Highways England Planning Response (HEPR 16-01) Formal Recommendation to 21/01630/OUT

Council's Reference: 21/01630/OUT

Location: Land at North West Bicester, Home Farm, Lower Farm and SGR2, Caversfield

Proposal: Outline planning application for residential development (within Use Class C3), open space provision, access, drainage and all associated works and operations including but not limited to demolition, earthworks, and engineering operations, with the details of appearance, landscaping, layout and scale reserved for later determination

Traffic Flow Diagrams

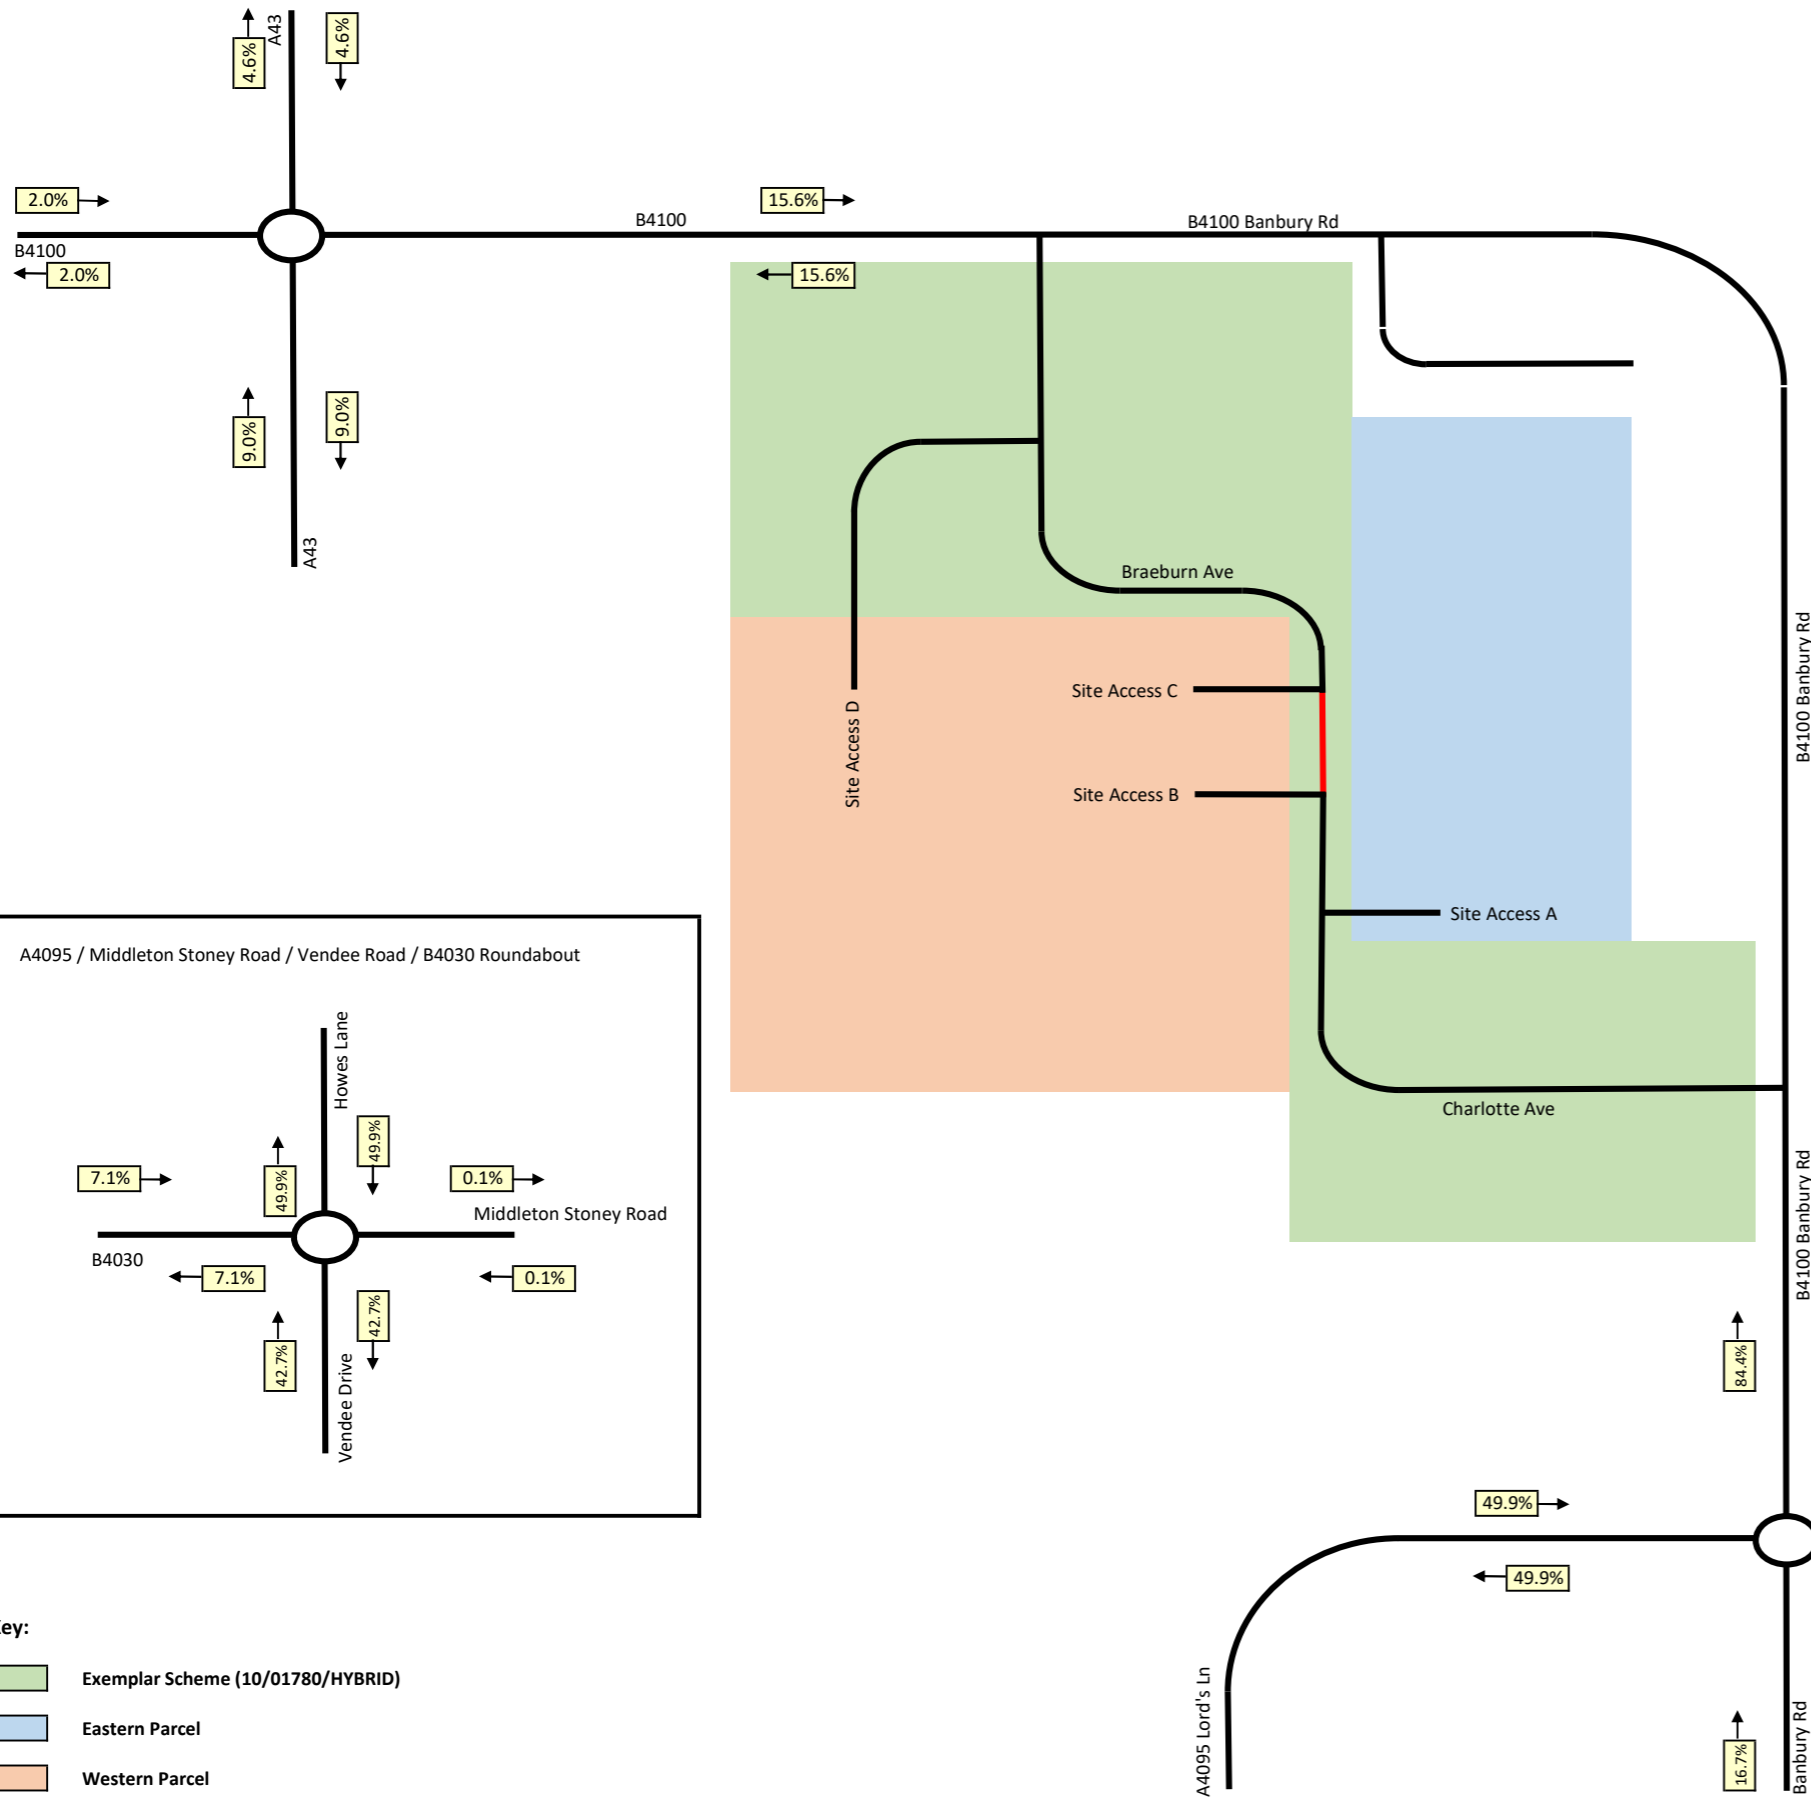
The impact of the development is not shown south at Junction 9 of the M40, development flows can be seen to travel south on the B4100, A4095 and subsequently Vendee Drive towards this junction but no further distribution is provided in the diagrams nor mentioned in the text. The highest flow shown being +83 southbound in the AM peak on Vendee Drive. We are content with the trip generation and distribution methodology, however more information is required to show the traffic impact and distribution at Junction 9 of the M40.

Highways England recommends that Local Planning Authority does not grant planning permission for the application for a period of 56 days (Ref: P21/10042/FUL) from the date of this recommendation to enable further assessment to be undertaken.
